**From:** Roger Reddel <rredel@cmri.org.au>  
**To:** Peter McManus <peter.mcmanus@planning.nsw.gov.au>  
**CC:** <assessments@planning.nsw.gov.au>  
**Date:** 22/10/2010 12:51 pm  
**Subject:** Online Submission from Roger Reddel of Children's Medical Research Institute (support)

Re: Application Number: MP 10\_0050

Submission for Job: #3887 MP10\_0050 - Westmead Millennium Institute (WMI) including Westmead Research Hub (WRH)

FLOOR PLAN
LEVEL 01 - UPPER GROUND
DRAWING NUMBER
DA-D-01
ISSUE
7

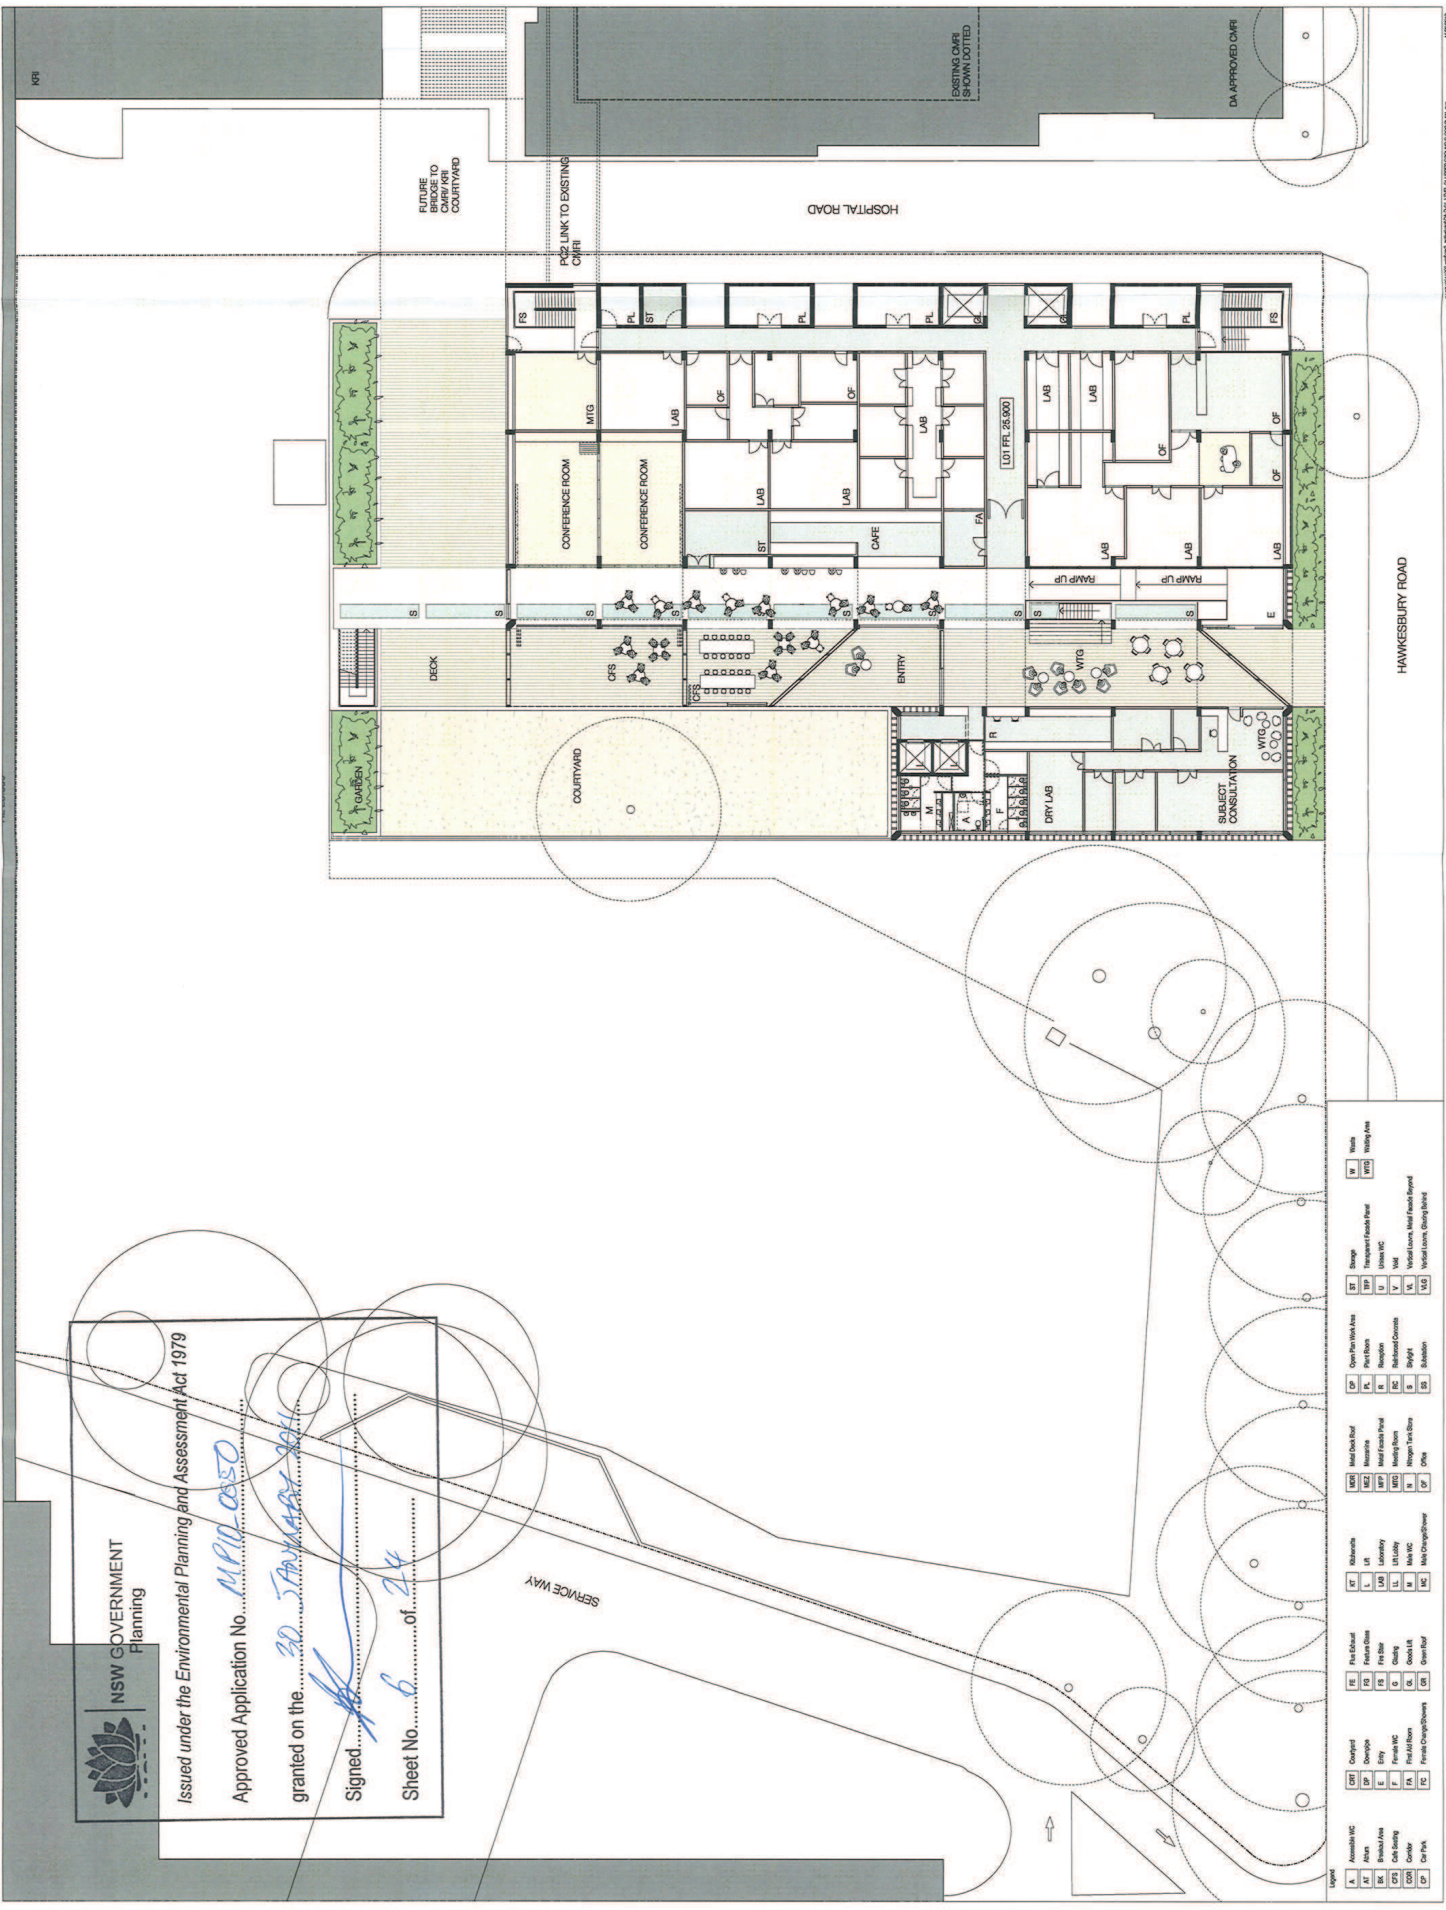
Our concerns relate primarily to the entrances. The CMRI plans referred to above are based on the framework delineated by the 10 April 2008 master plan prepared by Health Projects International which shows a park/forecourt area at the front of the WMI and WRH buildings. NSW Dept of Health (DOH) stated that is their intention that the forecourt should be the focal point and the entrance area for the surrounding research buildings. At the request of DOH, and to form a visual link between the

buildings, CMRI completely reoriented its building plan so that the entrance will address the planned park area. We are aware that this forecourt area was subsequently removed from the WMI/WRH plans so that the building could be located away from a helicopter flight path, but we consider that it should nevertheless be possible to design an entrance that creates a visual connection between the research buildings.

The second concern relates to entry to the Westmead Research Hub (WRH) component of the building. In the current plan, the WRH facilities are distributed somewhat diffusely throughout the building. CMRI's view is that these facilities should have a discrete presence, with visual and functional delineation, which includes a clearly defined entry.
